Re: Highlands Market Parking Lot
1111 Central Aven. NE
Traffic Circulation Layout
Engineer's/Architect's Stamp 01-07-2020 (K15D034D)

Based upon the information provided in your submittal received 01-07-2020, the above referenced plan cannot be approved for Building Permit until the following comments are addressed:

SITE DETAILS

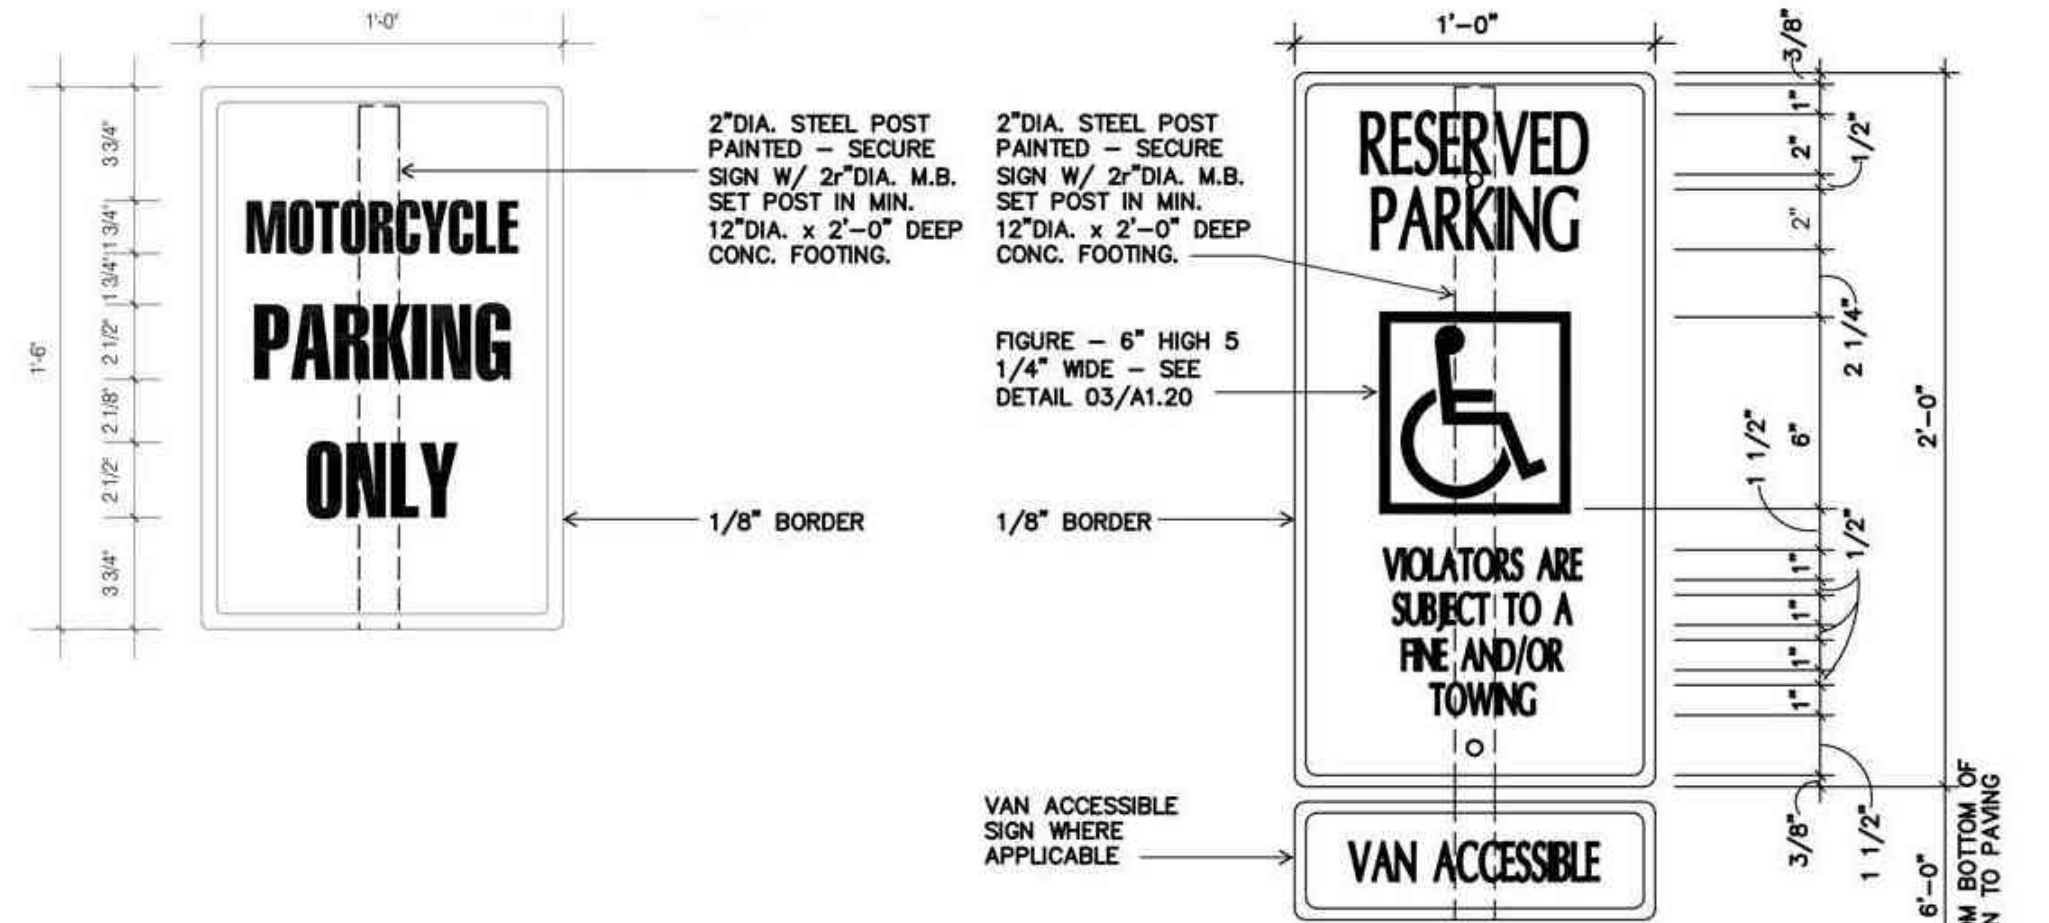
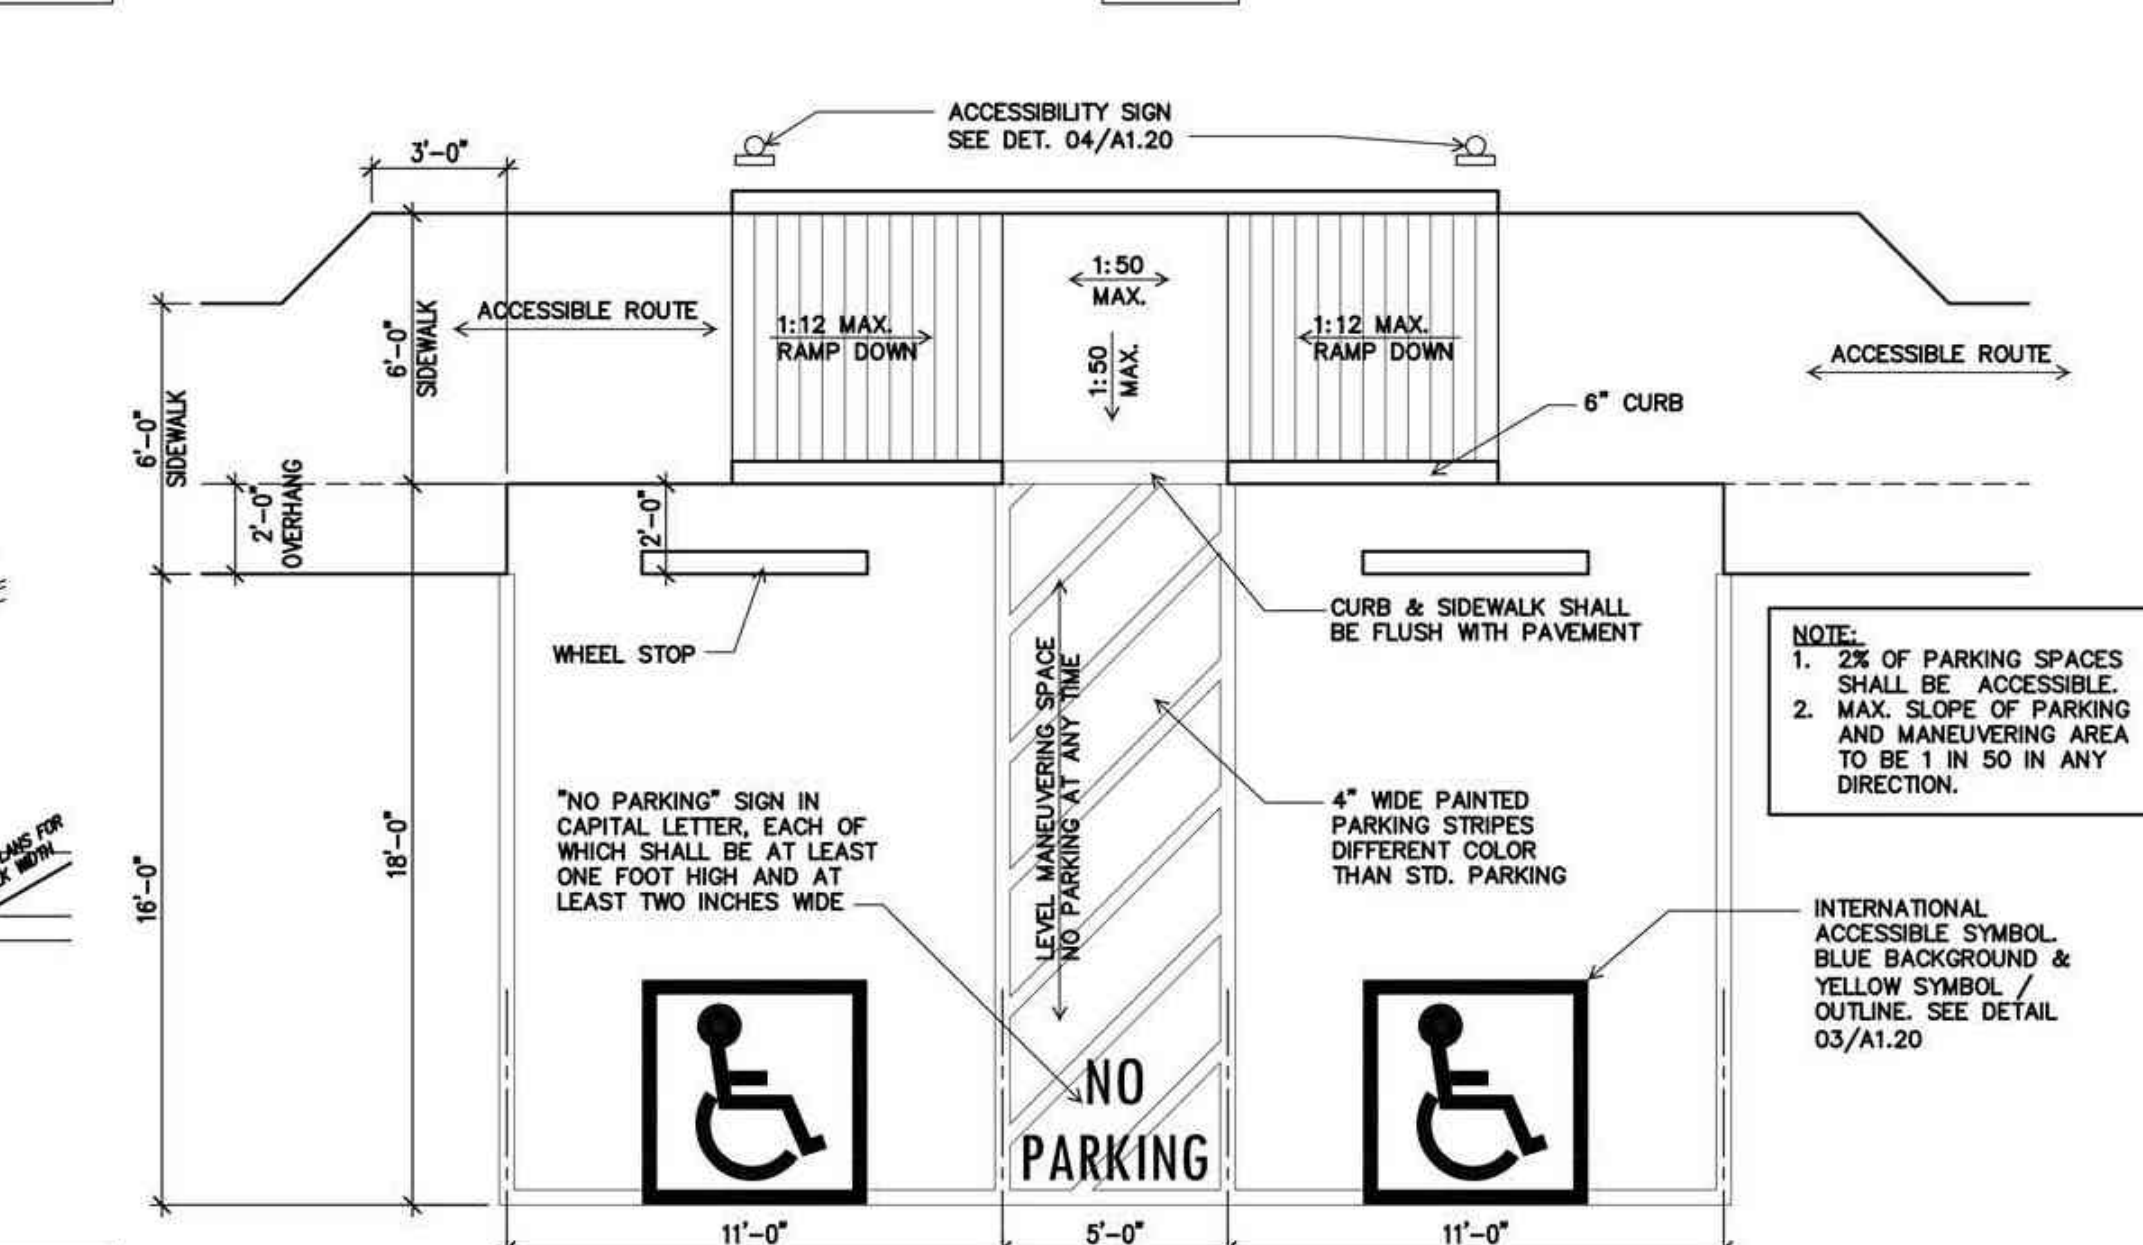
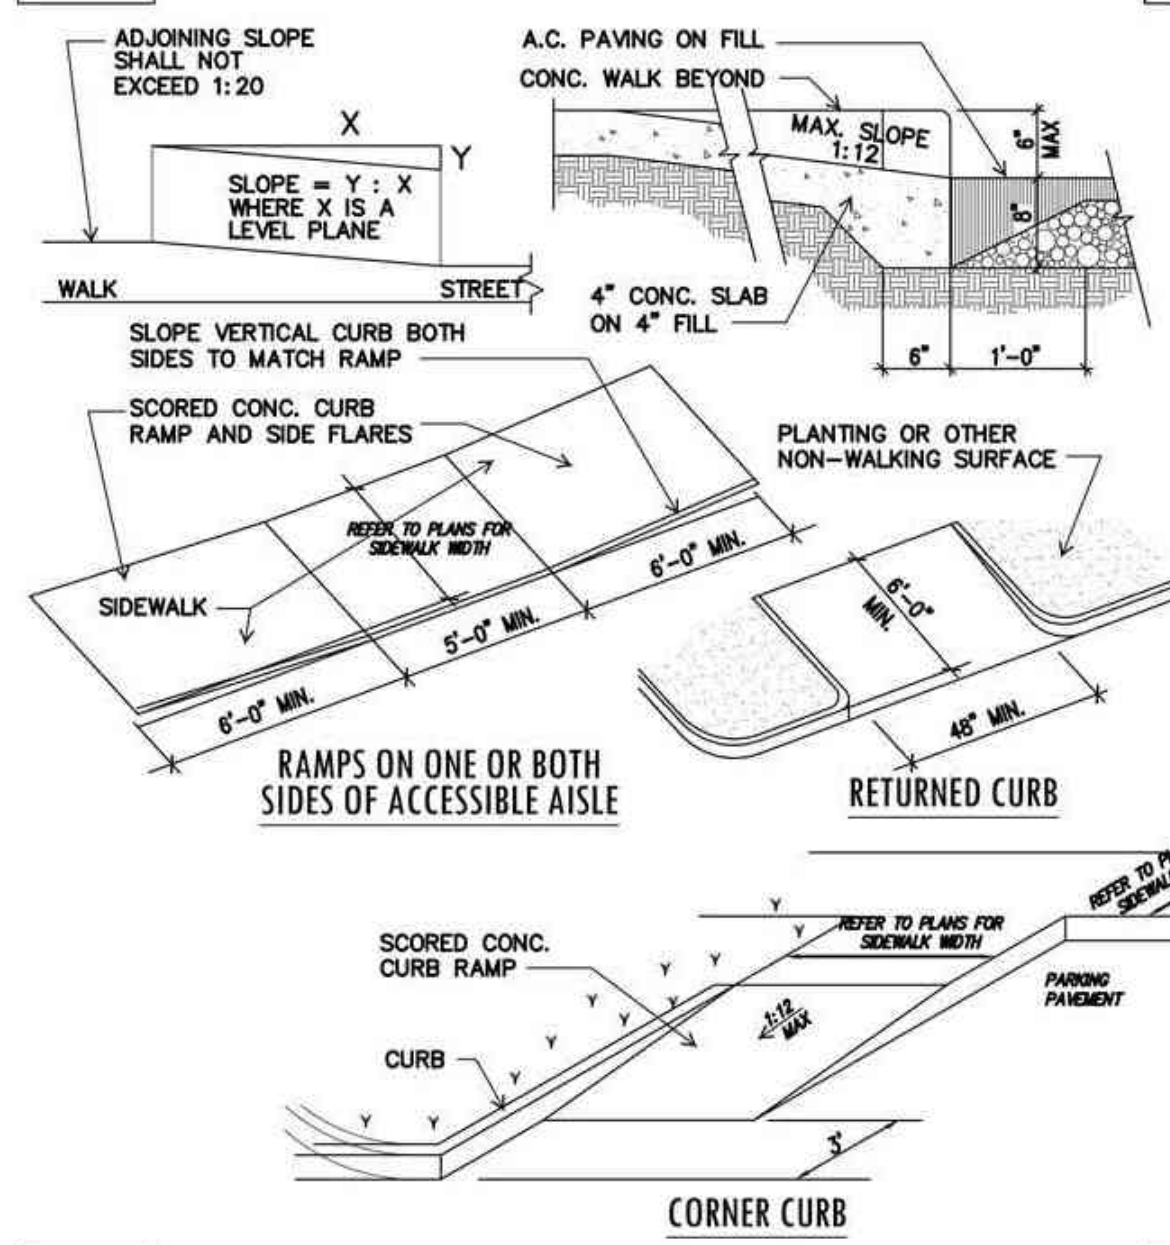
1. The parking table shows 35 spaces, but there are 32 spaces on site.
2. Where is the ADA space?
3. ADA curb ramps must be updated to current standards and have truncated domes installed.

4. Where is the motorcycle parking?
5. Where is the bicycle parking?
6. Per the IDO, a 6 ft. wide ADA accessible pedestrian pathway is required from the public sidewalk to the building entrances. Please clearly show this pathway and provide details.
